**CITY OF ALBUQUERQUE  
PLANNING DEPARTMENT  
December 19, 2012  
DRB Comments**

**PROJECT # 1009054**

**APPLICATION # 12-70380**

**RE: Lots F-K, Block 16, Del Norte Subdivision**

**LOMAS BOULEVARD, N. E.**  
 (100' R.O.W.)

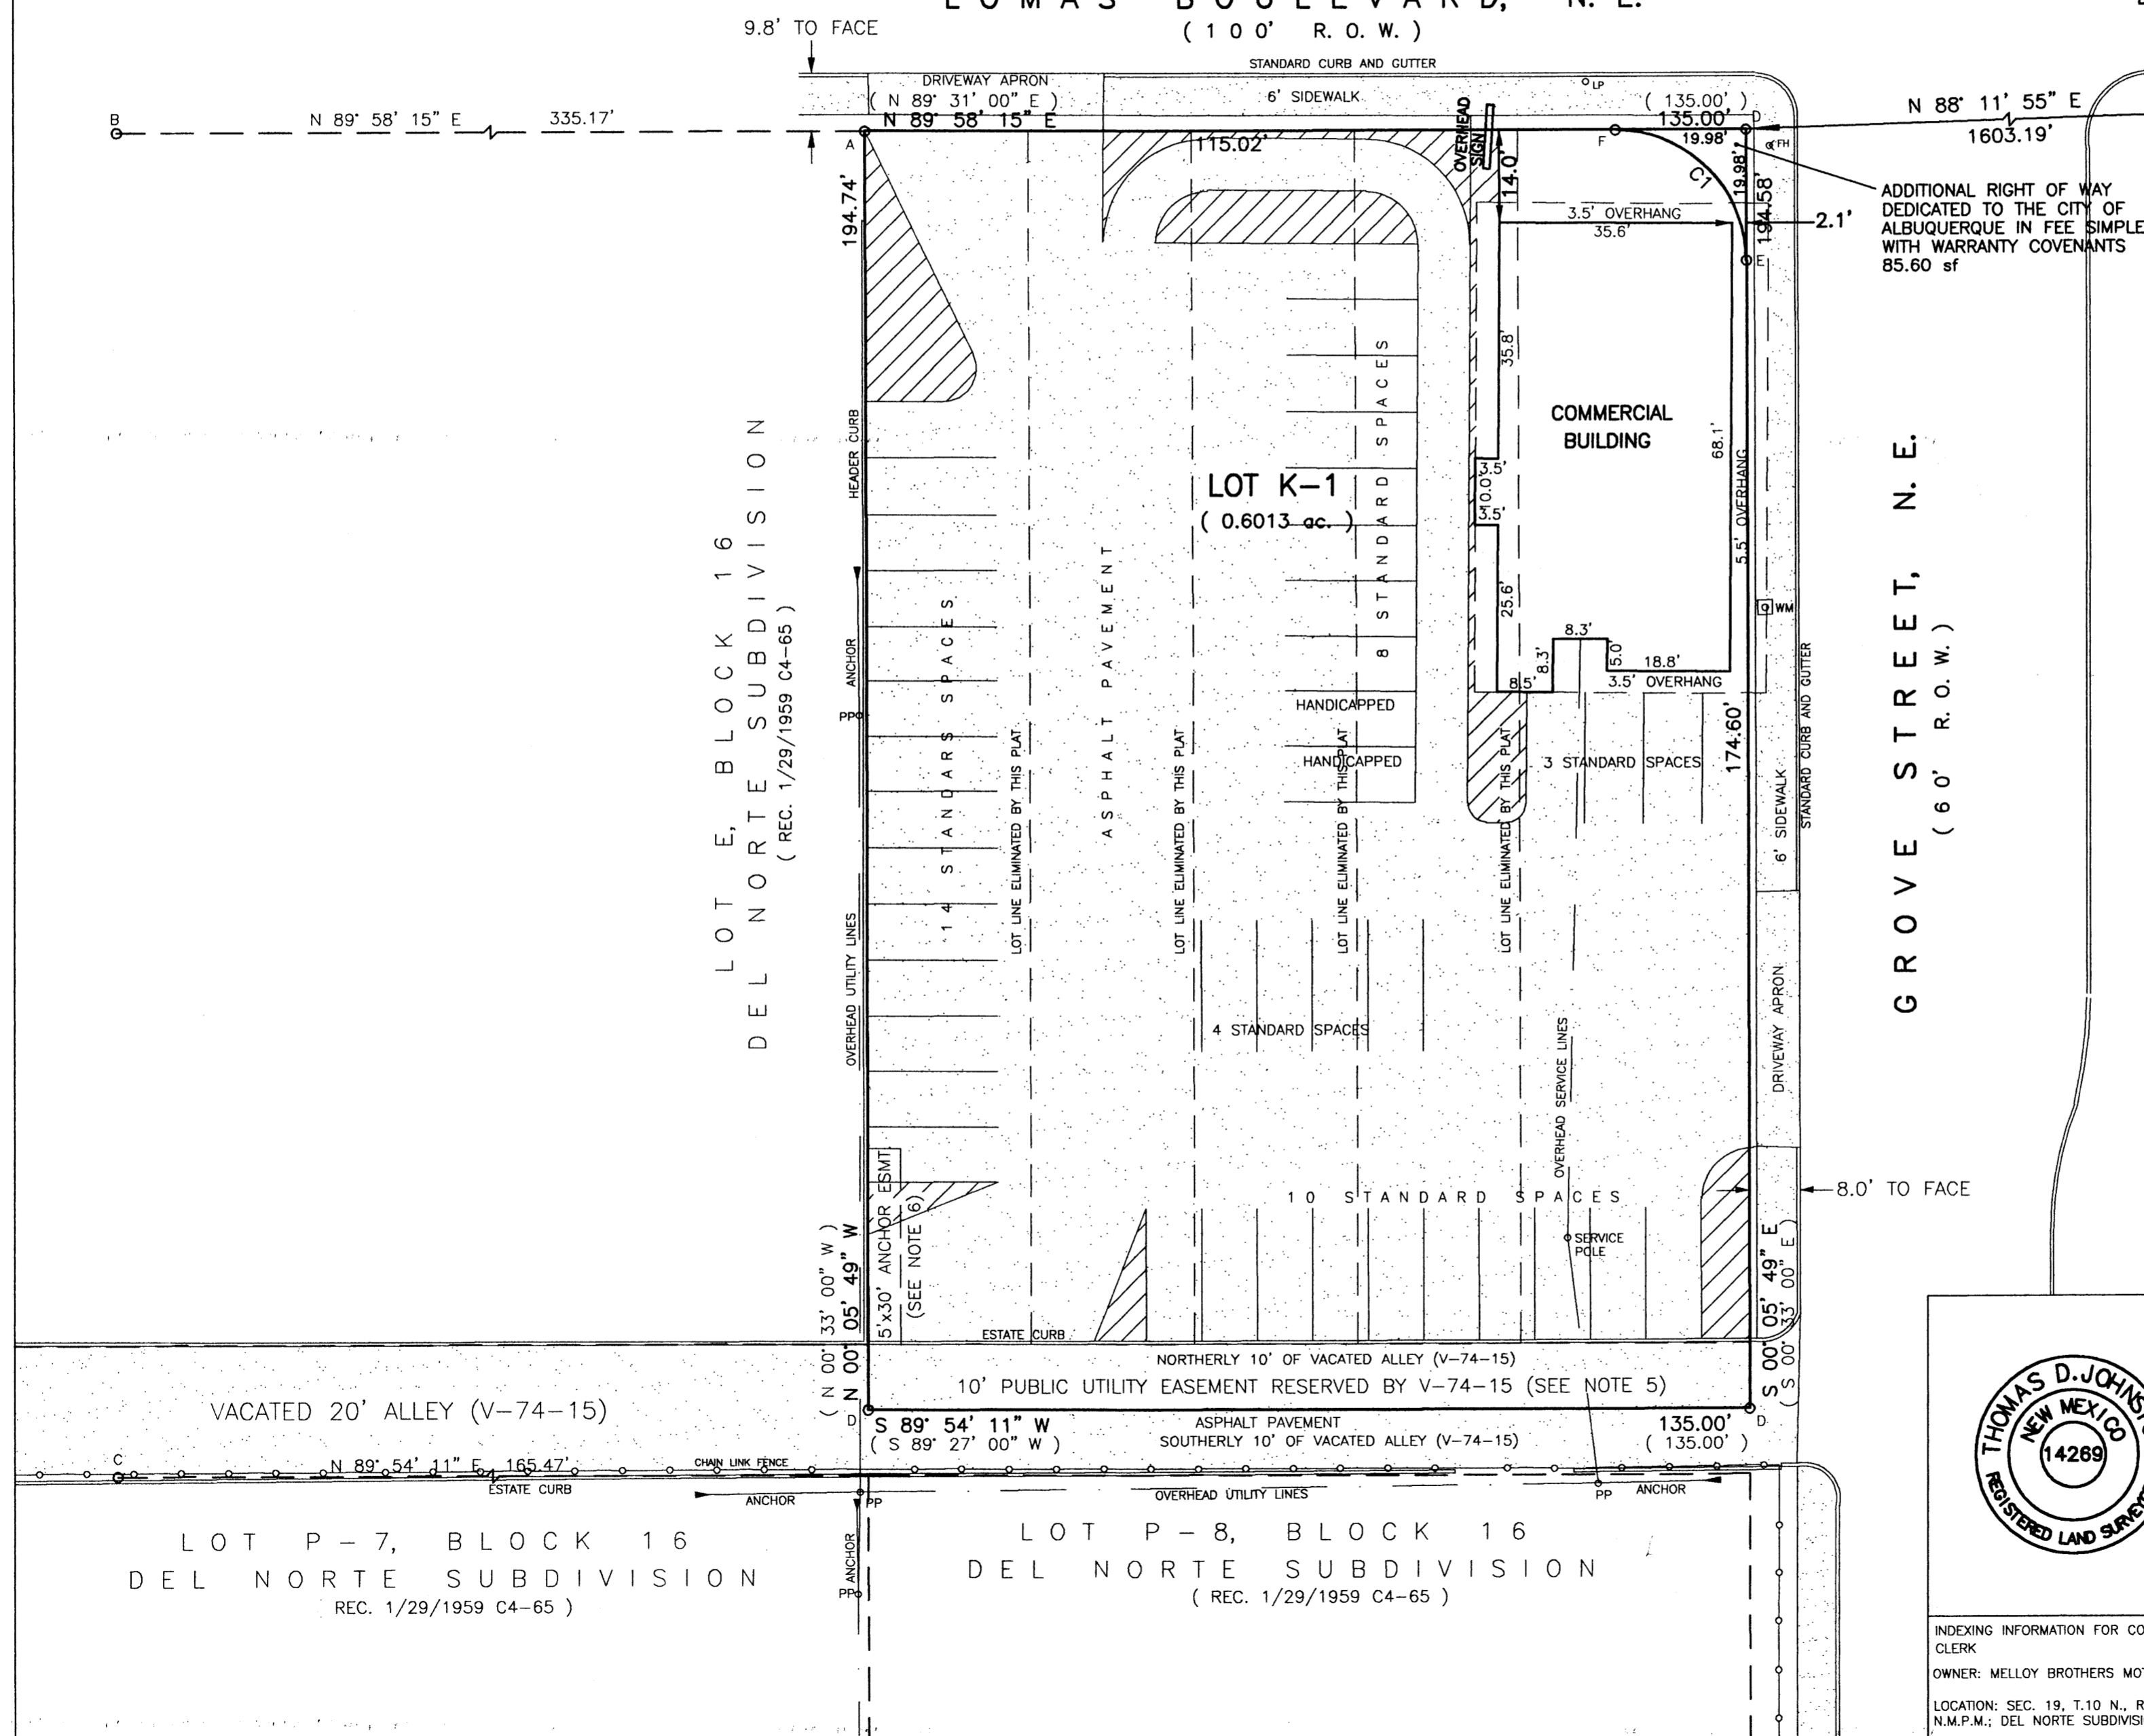
Clarify ownership status of the vacated alley by deed or signature from the City Real Property Division.
